### State Environmental Policy Act MITIGATED DETERMINATION OF NONSIGNIFICANCE

- Description:** The McIntosh Conditional Use Permit (CU-14-00004) is a proposed Small Scale Event Facility conducting more than eight events a year on approximately 50 acres of land that is zoned Agriculture 20.
- Proponent:** Scott and Gayle McIntosh, landowners.
- Location:** 3 parcels, located approximately 5 miles northwest of Ellensburg at 7820 Highway 97, in a portion of Section 08, T18N, R18E, WM in Kittitas County, bearing Assessor's map numbers 18-18-08020-0002, 18-18-08000-0002, and 18-18-08020-0003.
- Lead Agency:** Kittitas County Community Development Services

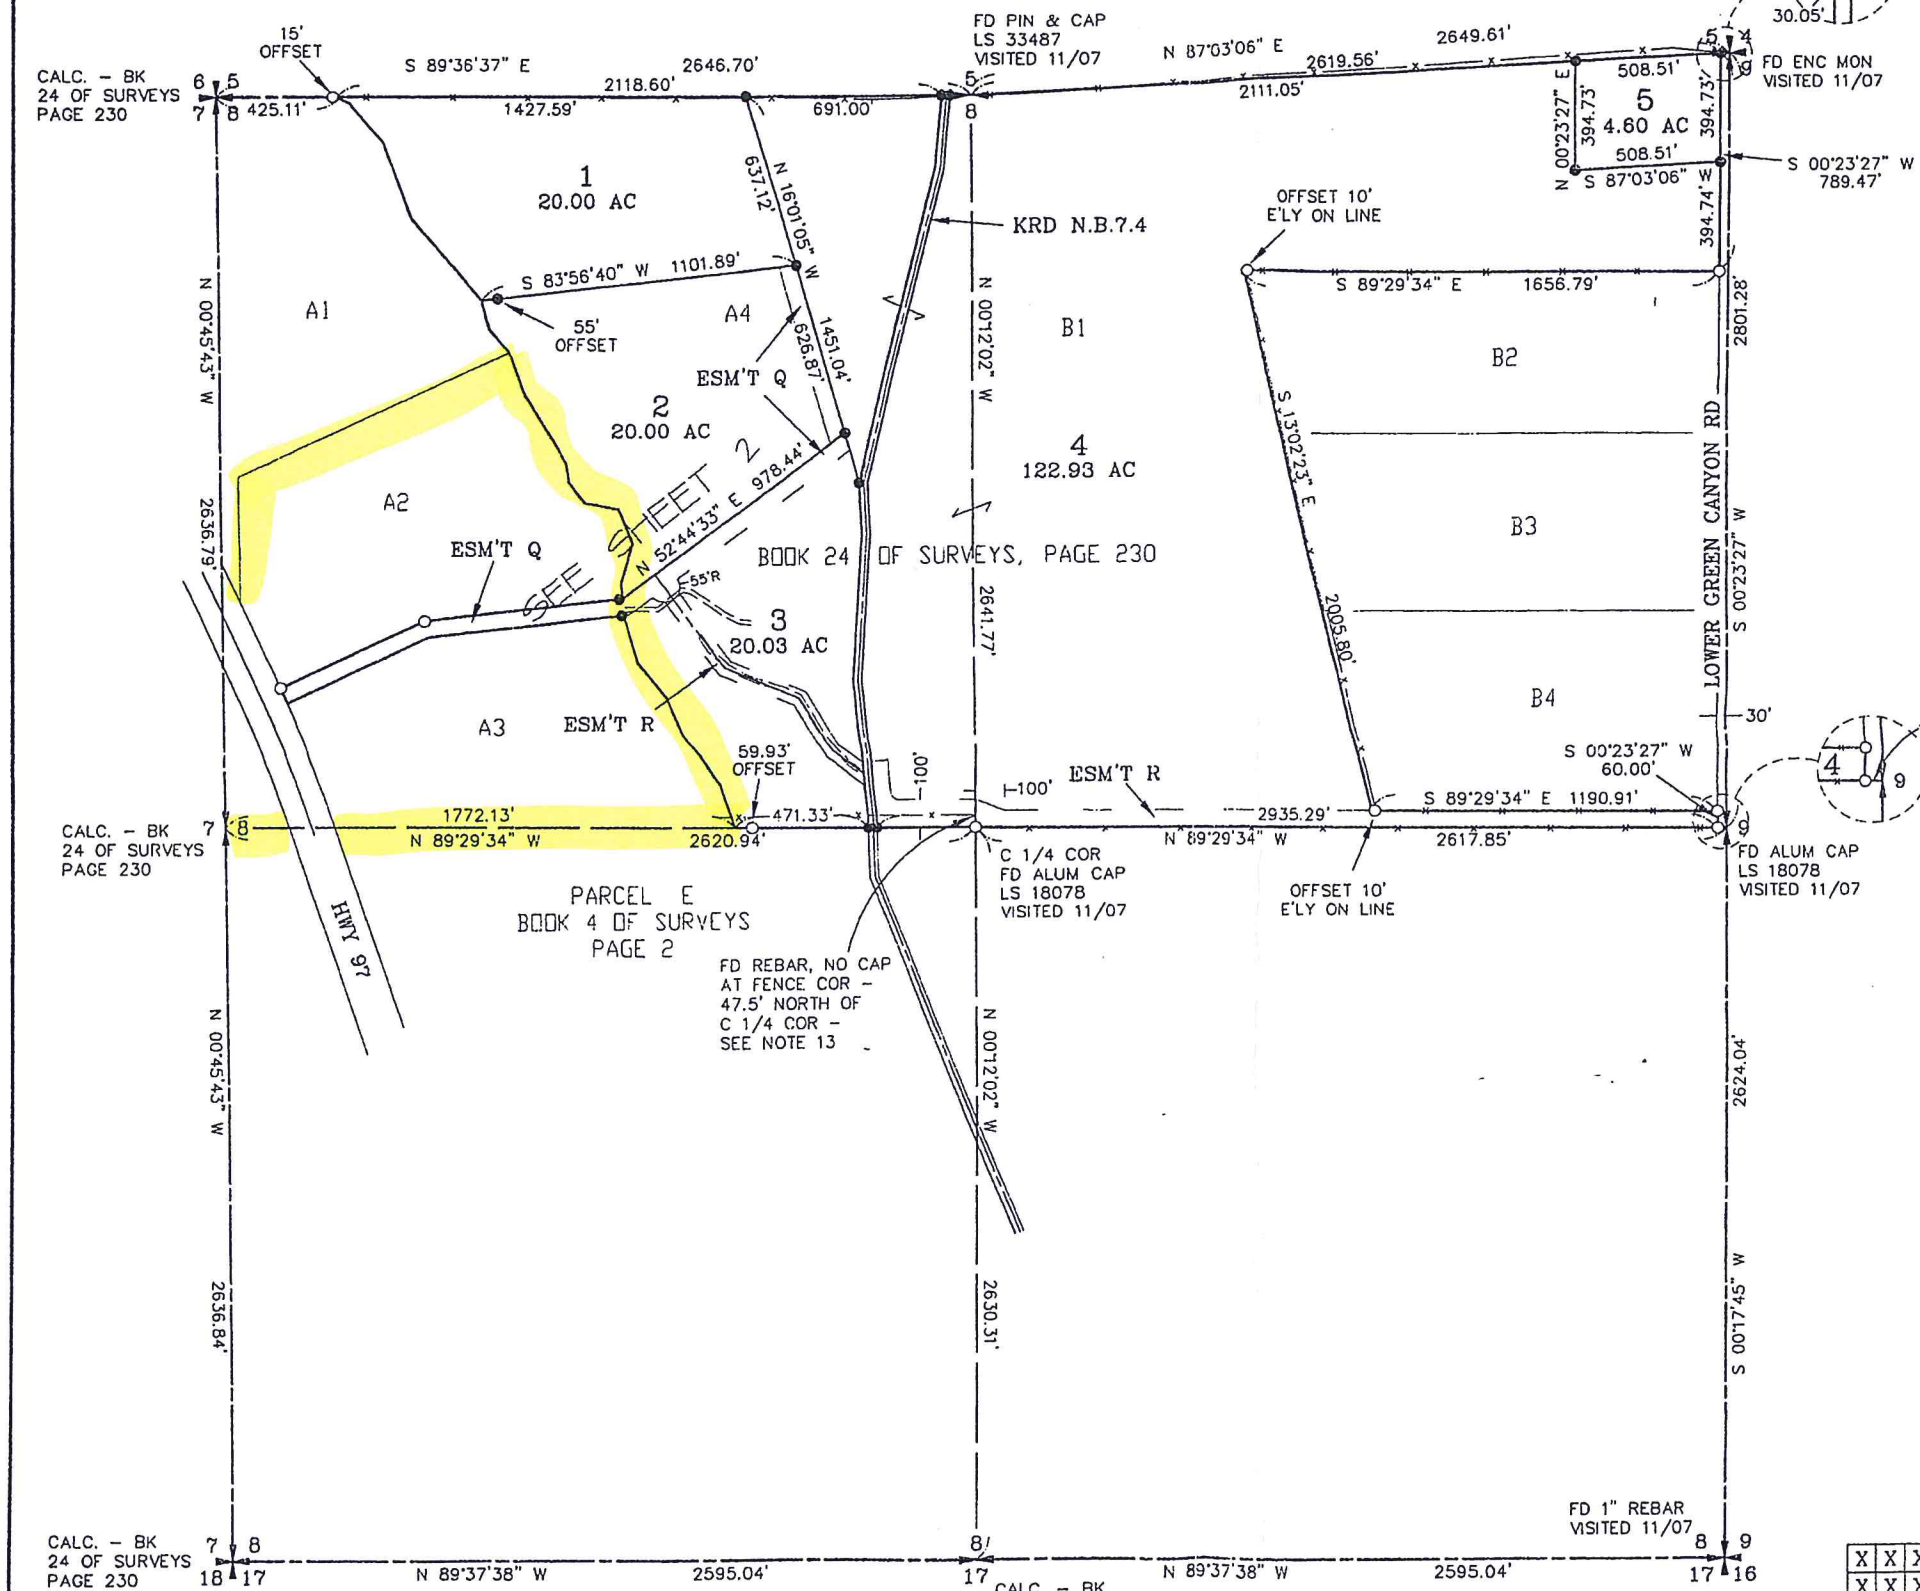
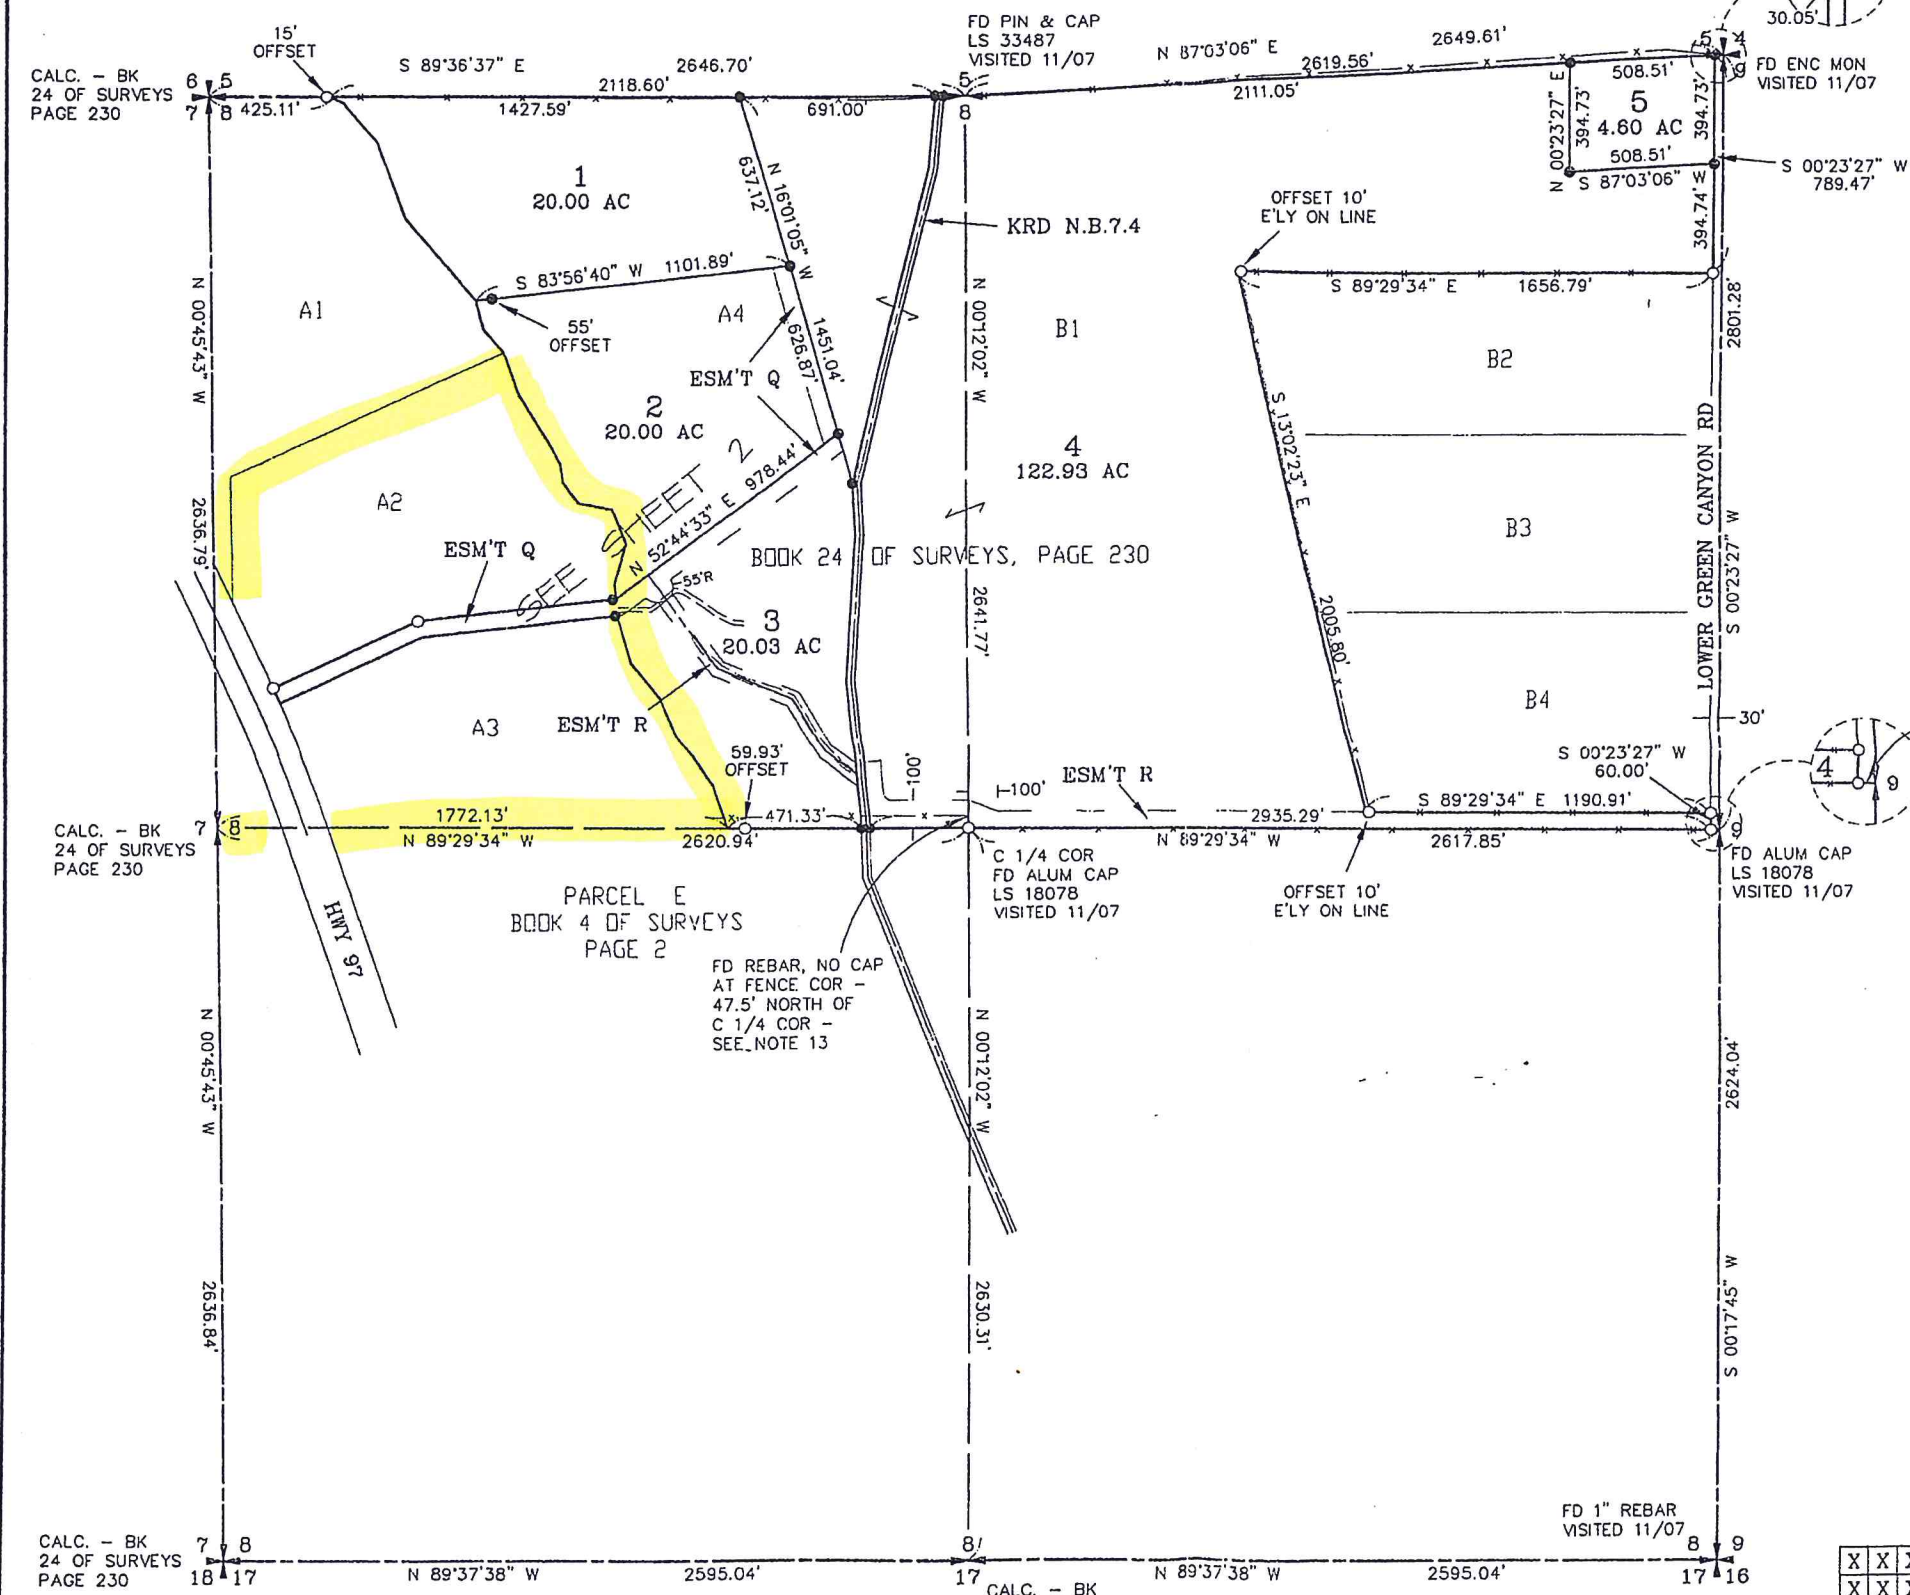
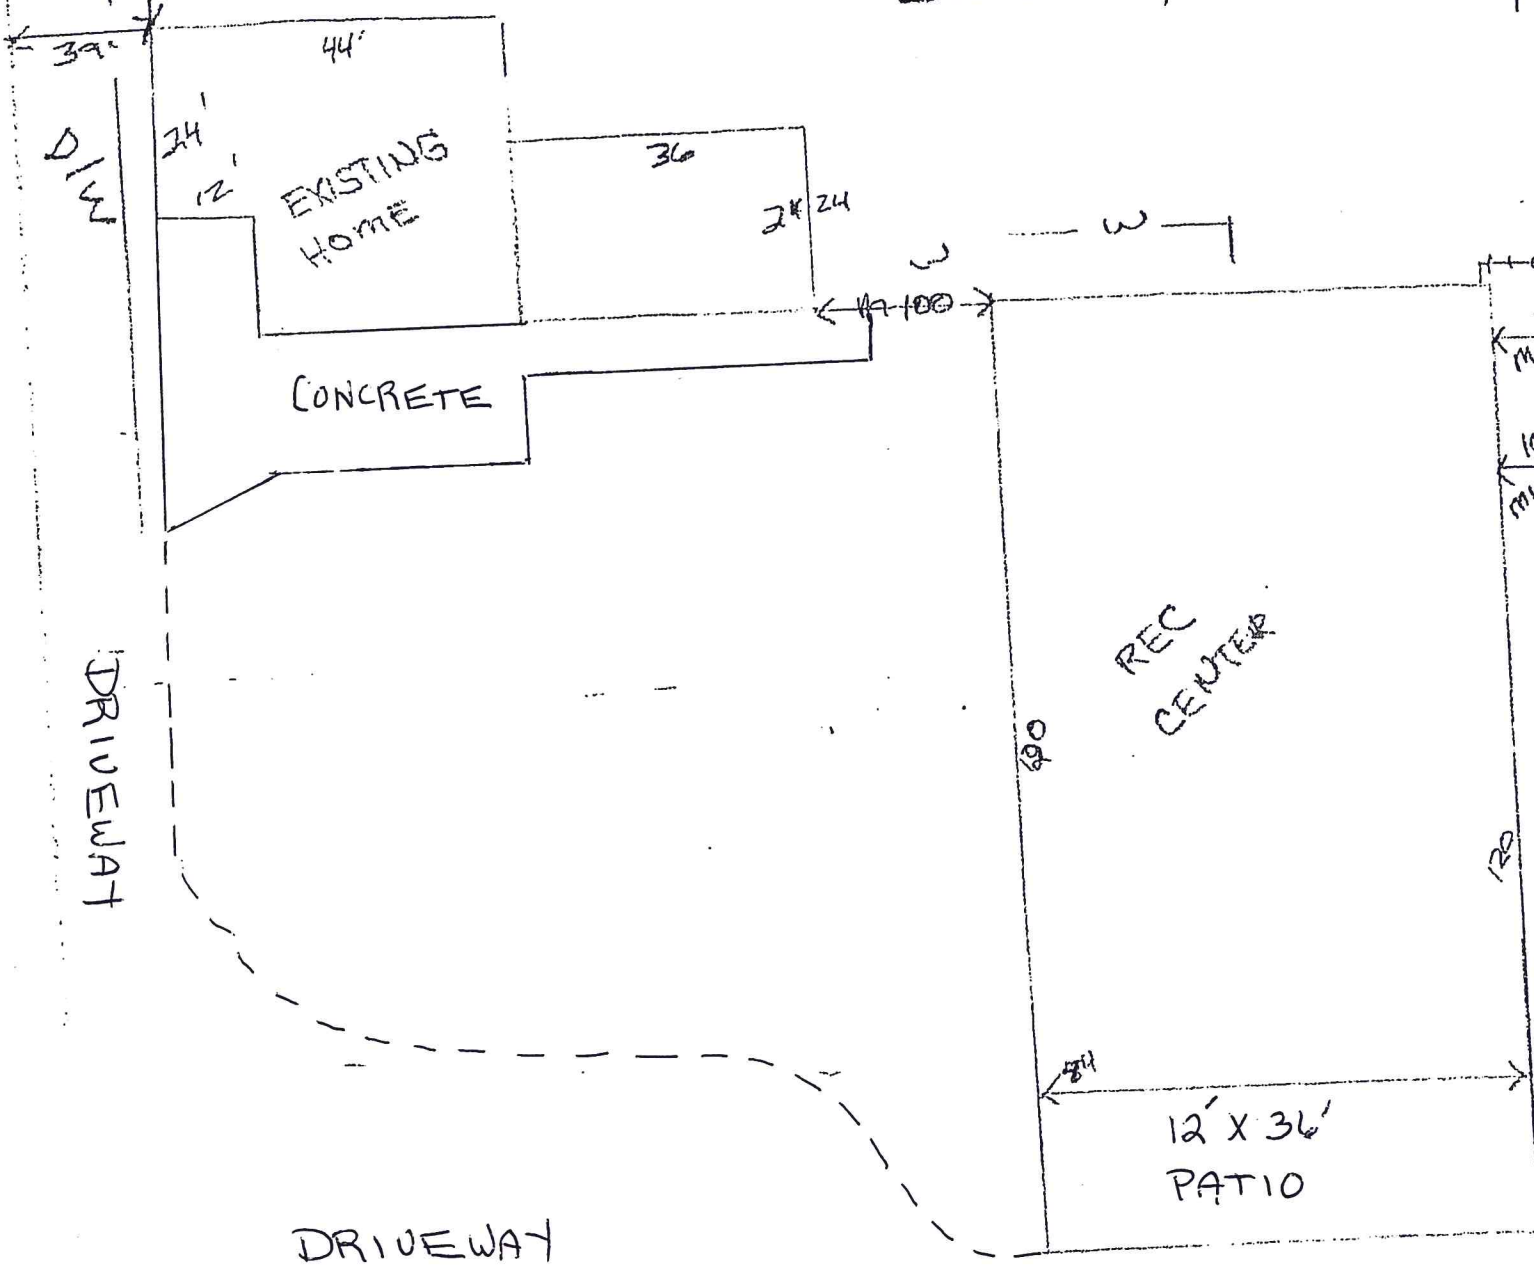
#### Water

- 9) Parking will not be permitted within WSDOT right-of-way. Appropriate on-site parking provisions are required during events. The decommissioned roadbed lying parallel to US 97 on the east side of the highway is within WSDOT right-of-way.

- 10) Parking shall be provided for a minimum of 75 vehicles and designed in a manor to allow full access to emergency vehicles at all times. A fixed parking plan shall be developed by the applicant and approved by the Kittitas County Fire Marshal and Kittitas Valley Fire and Rescue

- 15) The structures currently on the premises which are intended for use in conjunction with the proposed small scale event facility conditional use permit are not classified for occupancy correctly. The structure identified on the submitted site plan as the “Rec Center” shall be defined as an A-2 Assembly Occupancy and must meet all requirements as such in the 2012 International Building Code (IBC).
